**Consultation Response from Trees Planning,
KC Trees**
2019/90634 adj, Netherfield House, 12, Riley Lane, Kirkburton, Huddersfield, HD8 0RY
Erection of detached dwelling with associated landscaping, incorporating existing garage and private driveway
Date Responded: 13/03/20
Responding Officer: JR
Responding Ref: TPO 07/89

Drawing No:
Arbtech TCP 01

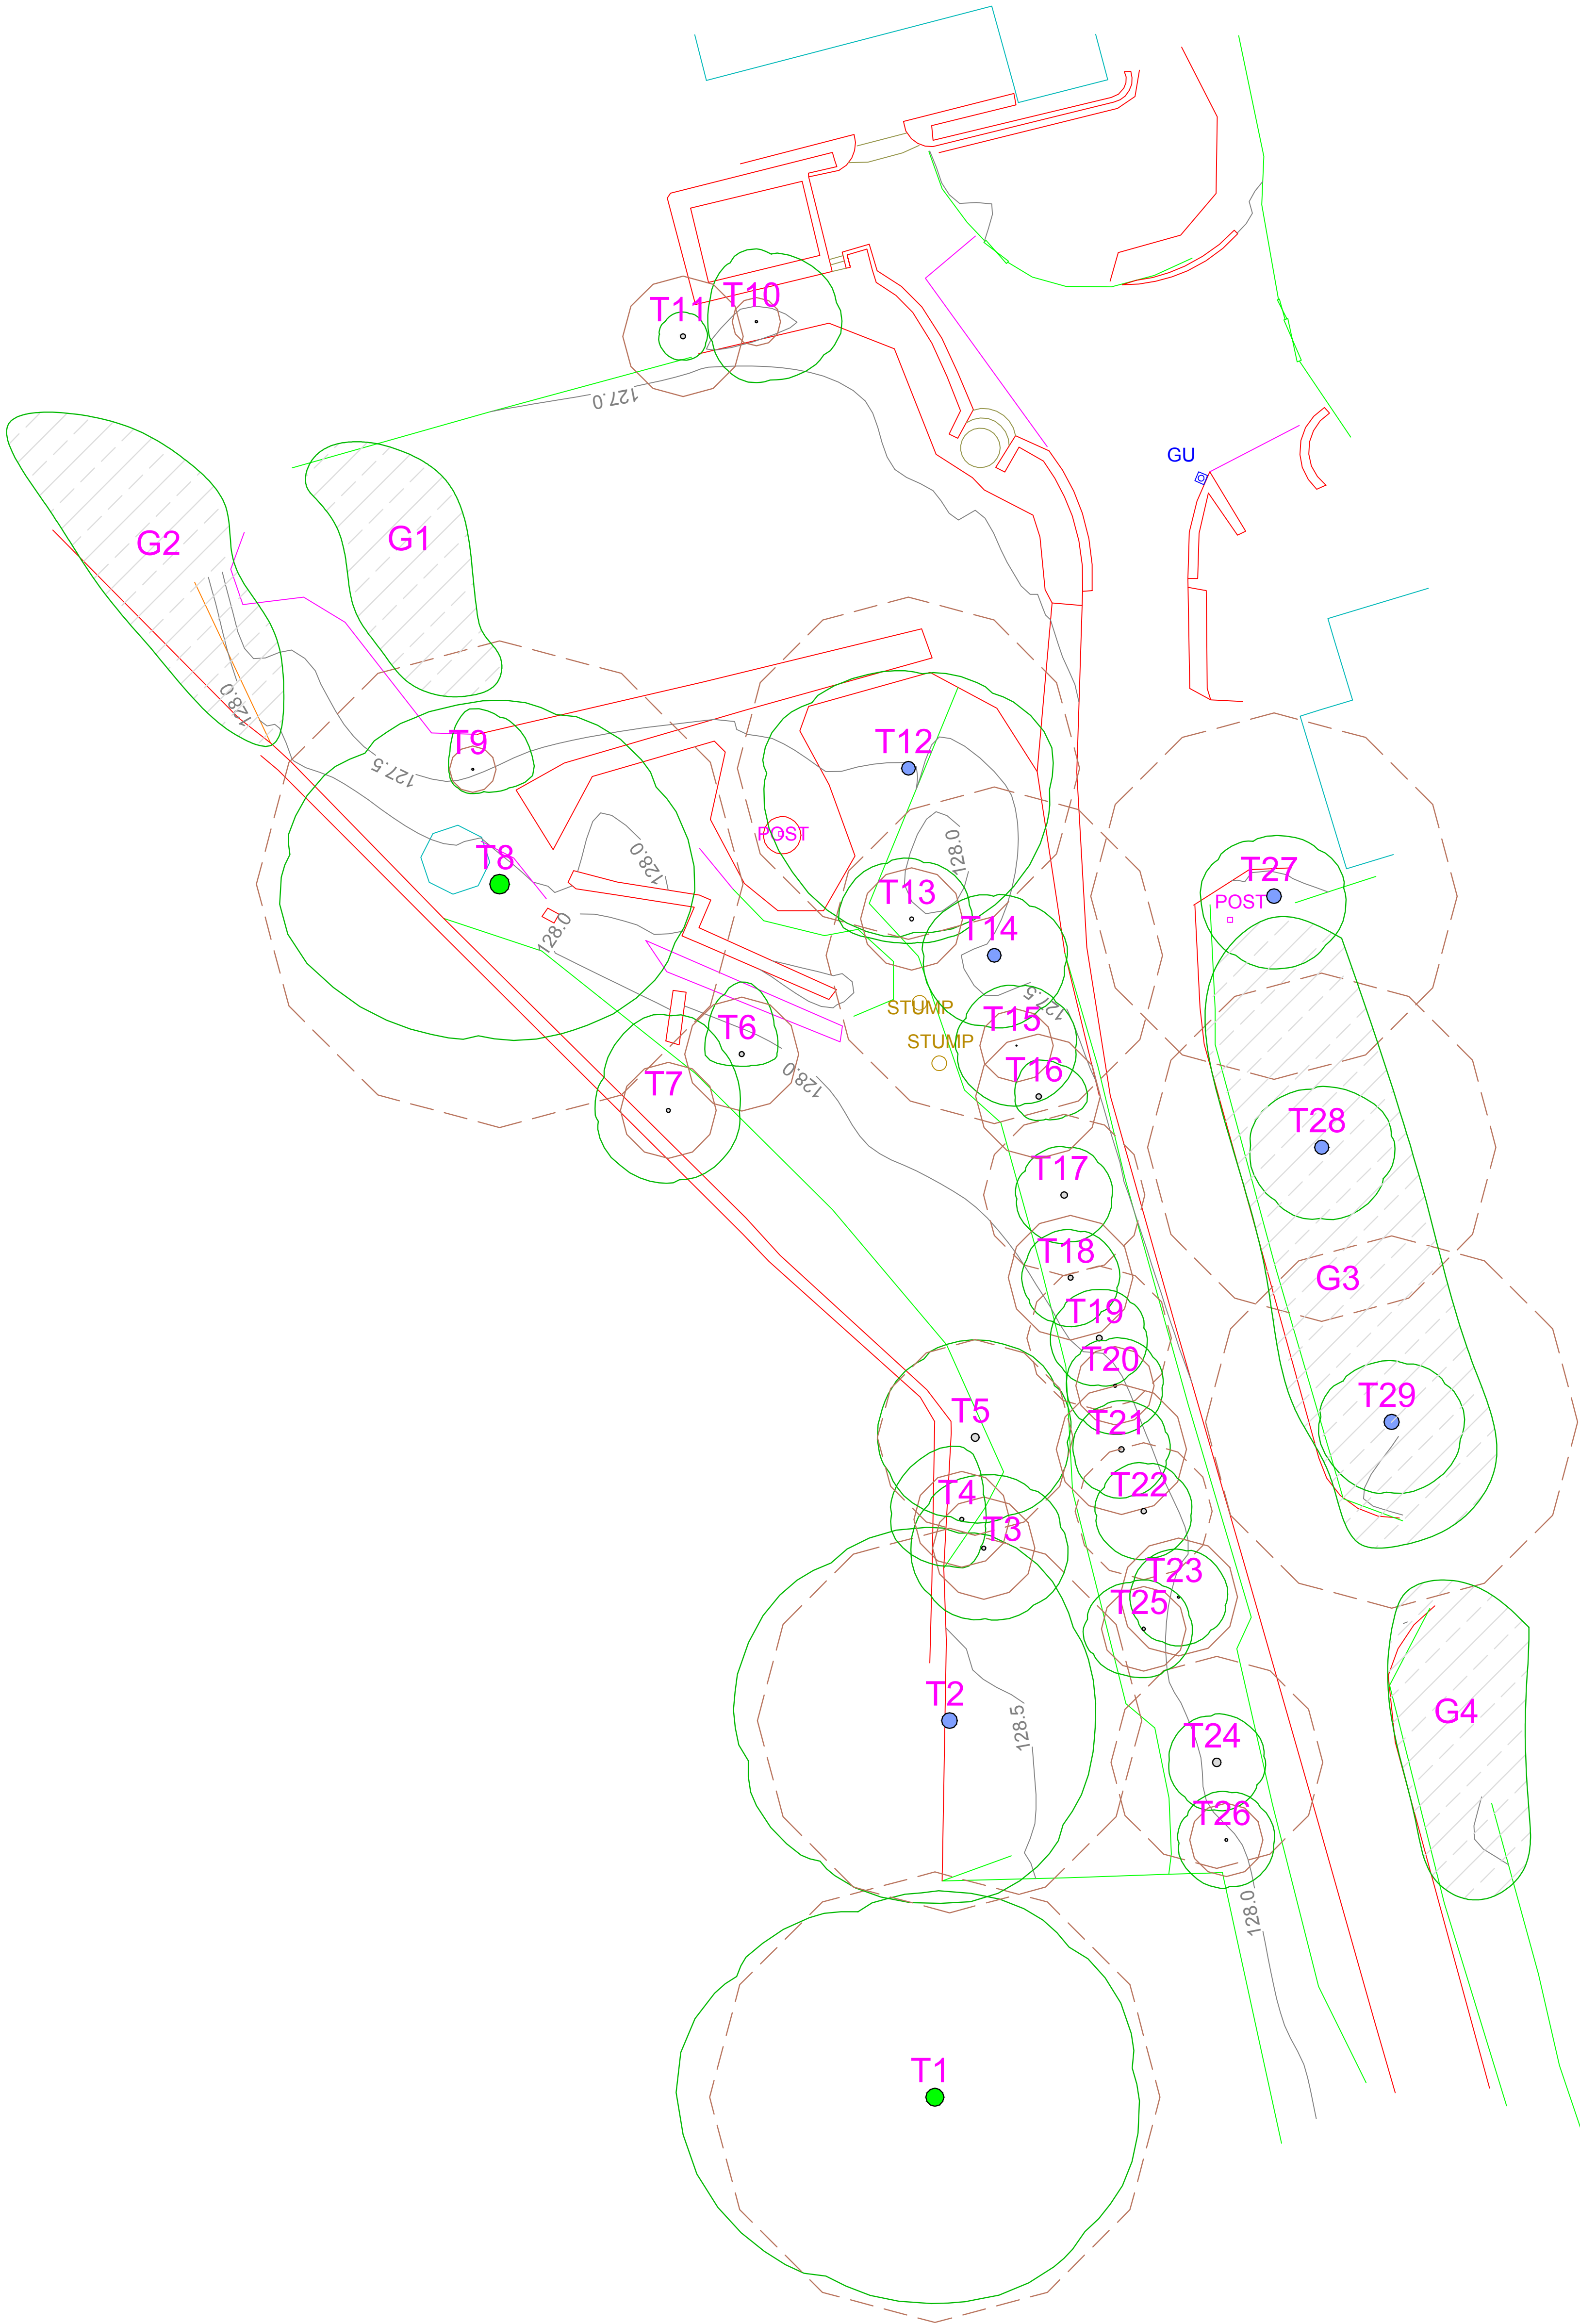
However, the proposal still appears to bring development works within the root protection area (RPA) of this tree. The design does not appear to have taken account to the RPA shown in the tree survey which supports the application.

The tree data from the tree survey needs to be transposed on to a layout plan, to include the RPA, as shown. This will aid any necessary design amendments to ensure that there are no development/construction activities within the RPA. It will also help the application demonstrate that there will be no adverse impact on protected trees.

Site Plan

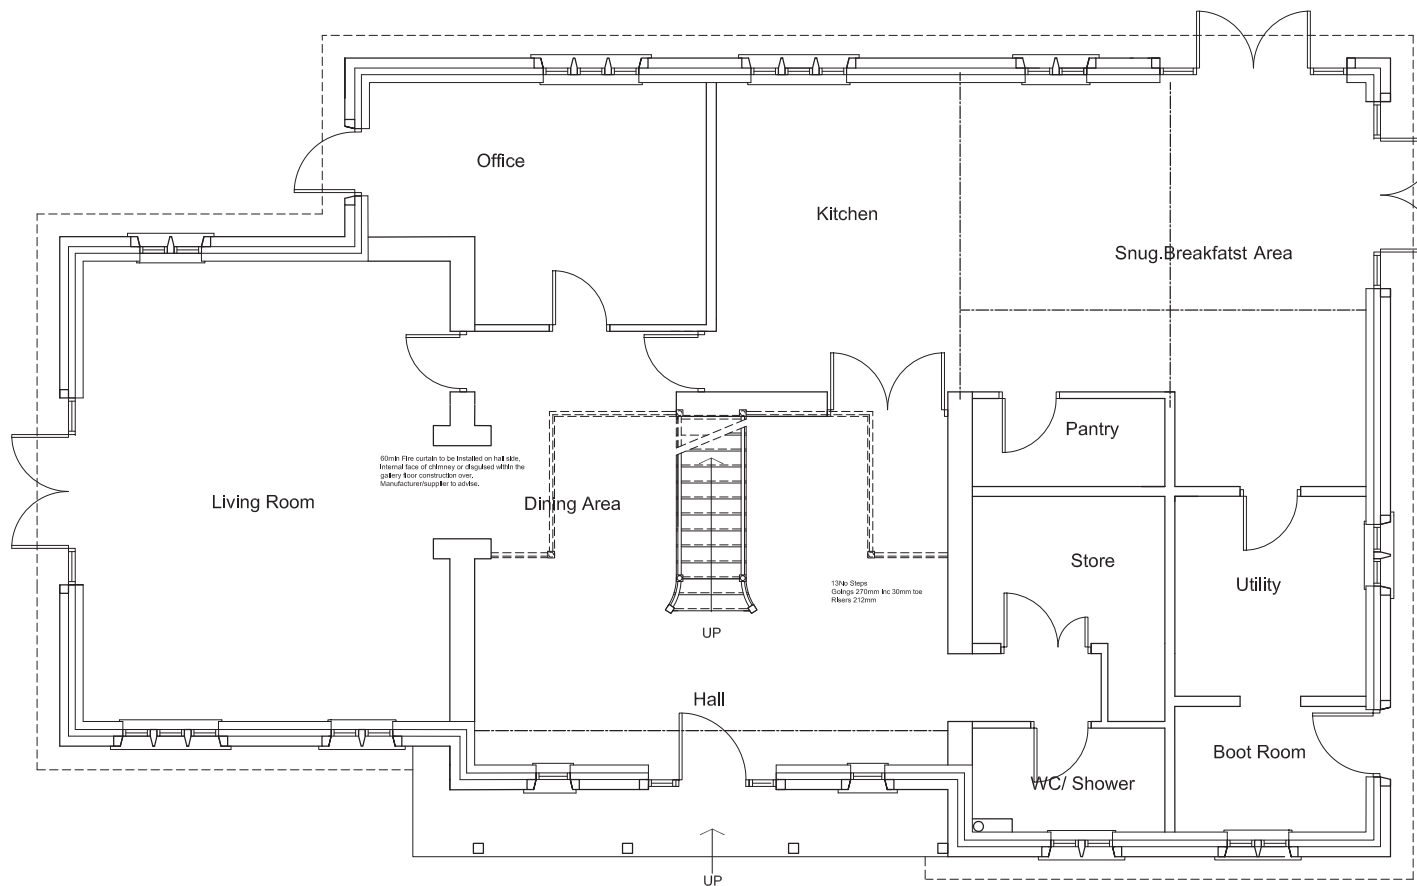
The amended design now shows the retention of T8, a large mature Oak, which is welcome.
